DECISION DELEGATED TO HEAD OF PLANNING

Application No: H09-0453-25 **Applicant:** AMP Clean Energy

Proposal: Details of landscaping scheme & boundary treatments (Conditions 4 & 6 of H09-0110-25)

Location: Land East Of Boston Road Holbeach Spalding

BATTERY BOX
Plan depicting 2.4m high Paladin Fencing

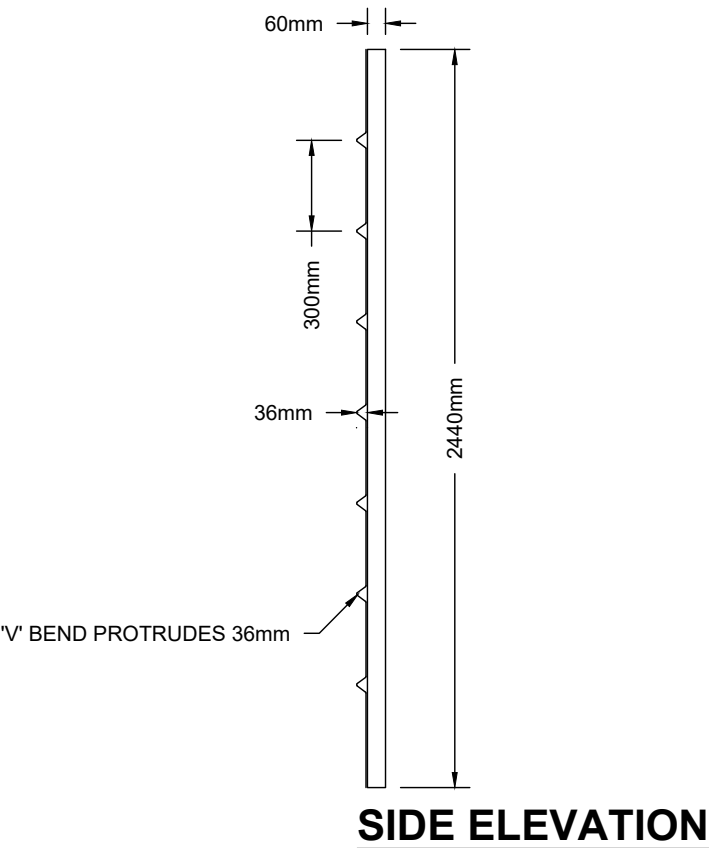
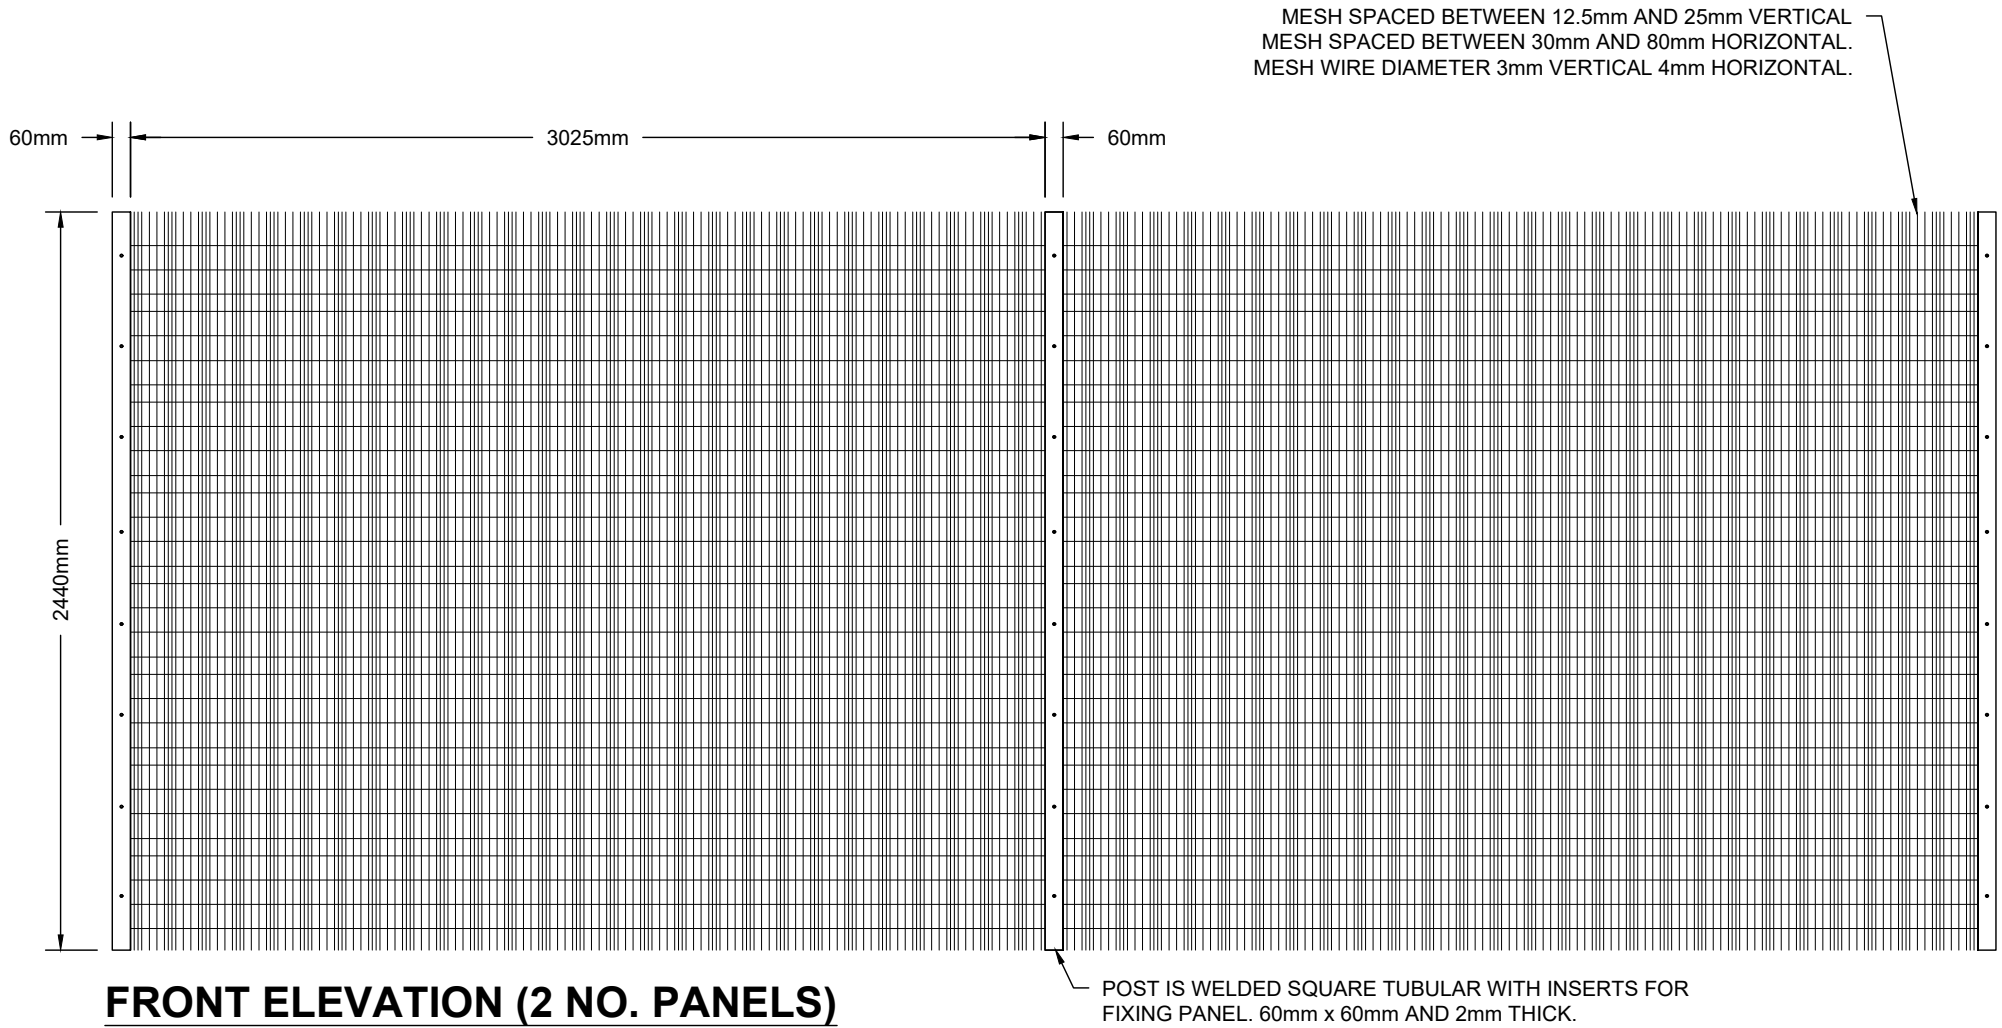
The submitted details illustrate the erection of fencing, consisting of Paladin Fencing which forms a mesh style boundary, to be sited around the immediate vicinity of the micro energy box and concrete base. Beyond this, the submitted details show landscaping, in the form of mixed planter boxes, to be located on the north side of the proposed development.

These details are appropriate for the setting and are considered to be suitable for the character of the area and neighbouring residents, whilst ensuring adequate function and appropriate visual amenity. These details are therefore considered acceptable.
